Your ref:  
Our ref: 23/00090/F  
Please ask for: Luke Swales  
Direct dial: 01553 616865  
E-mail: borough.planning@west-norfolk.gov.uk

Details: **Proposed detached double garage to front of clients property at Violet Cottage  
24 Common Road Snettisham King's Lynn Norfolk**

Location Plan
Scale: 1:1250

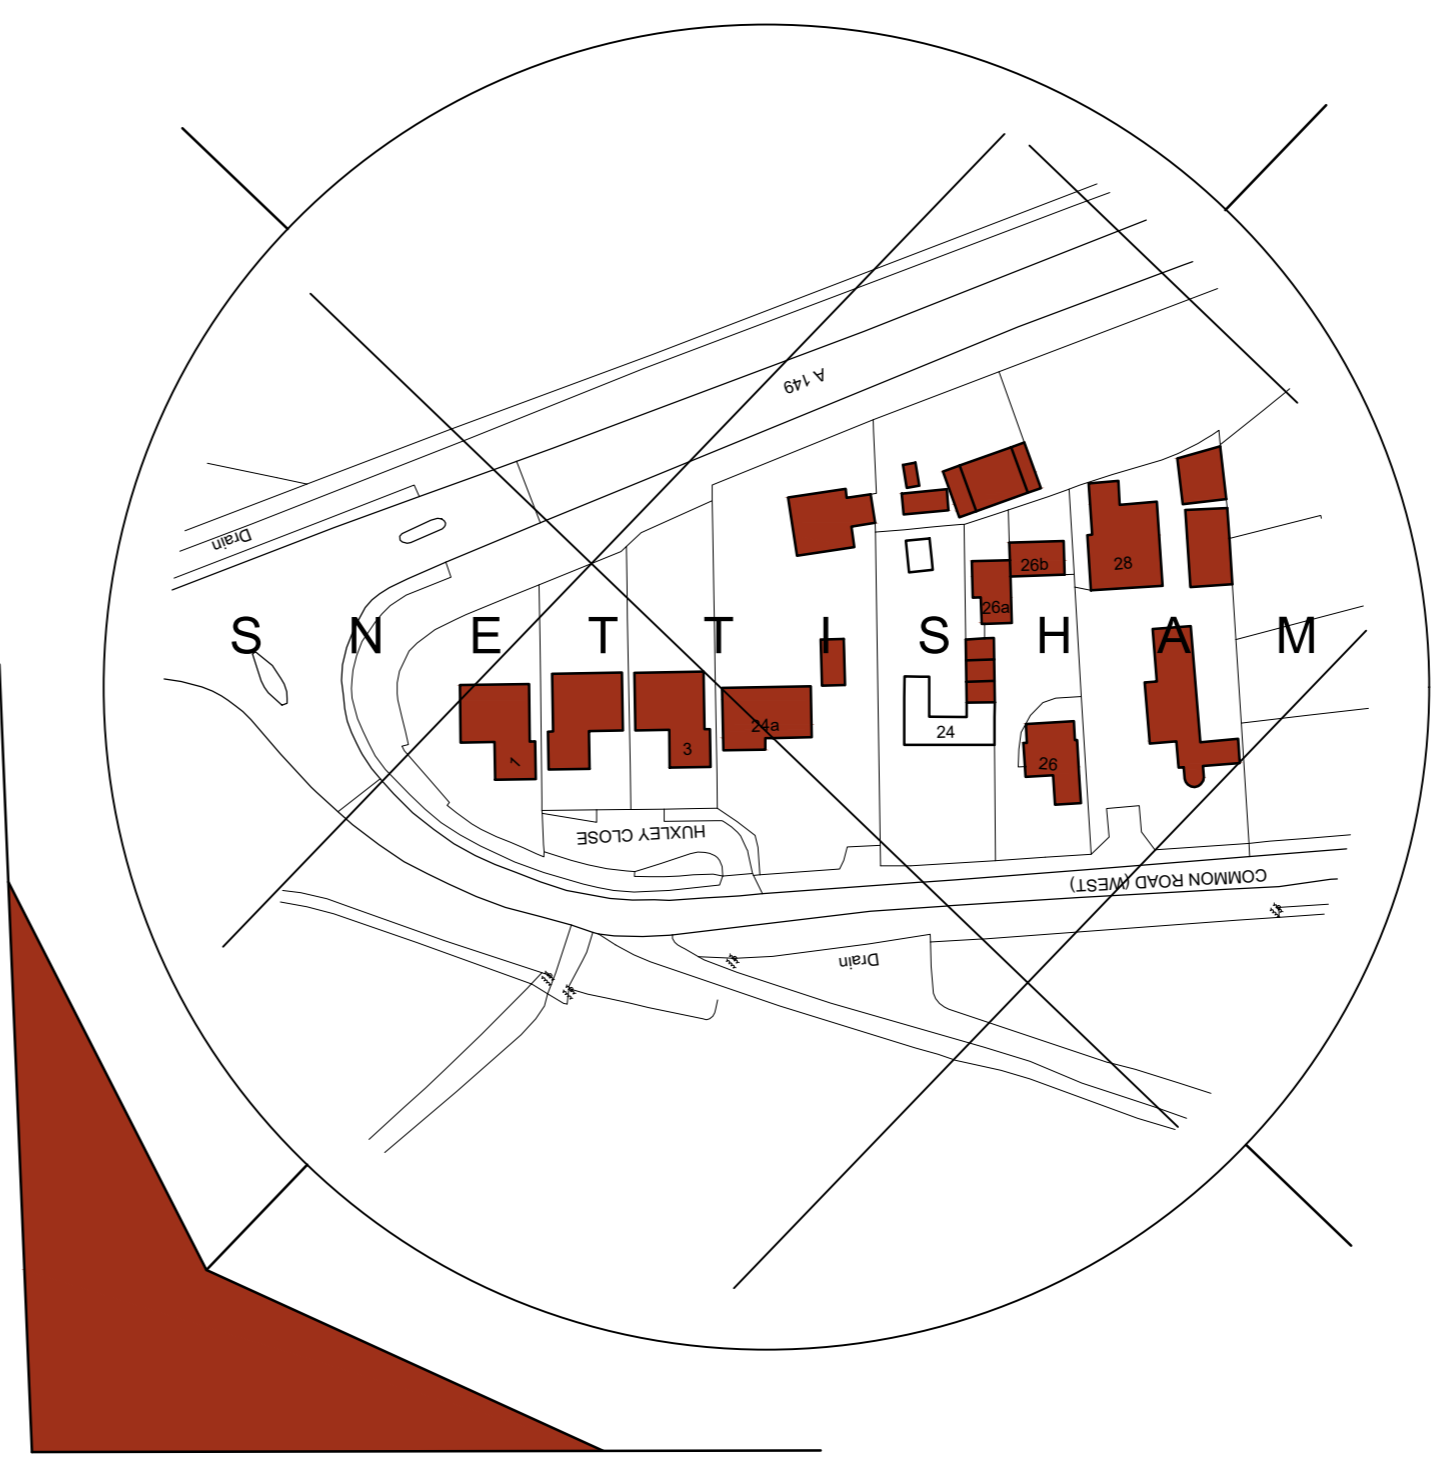
1. It appears that no red lines have been drawn on the existing location plan. Please add a red line to the existing location plan and resubmit.
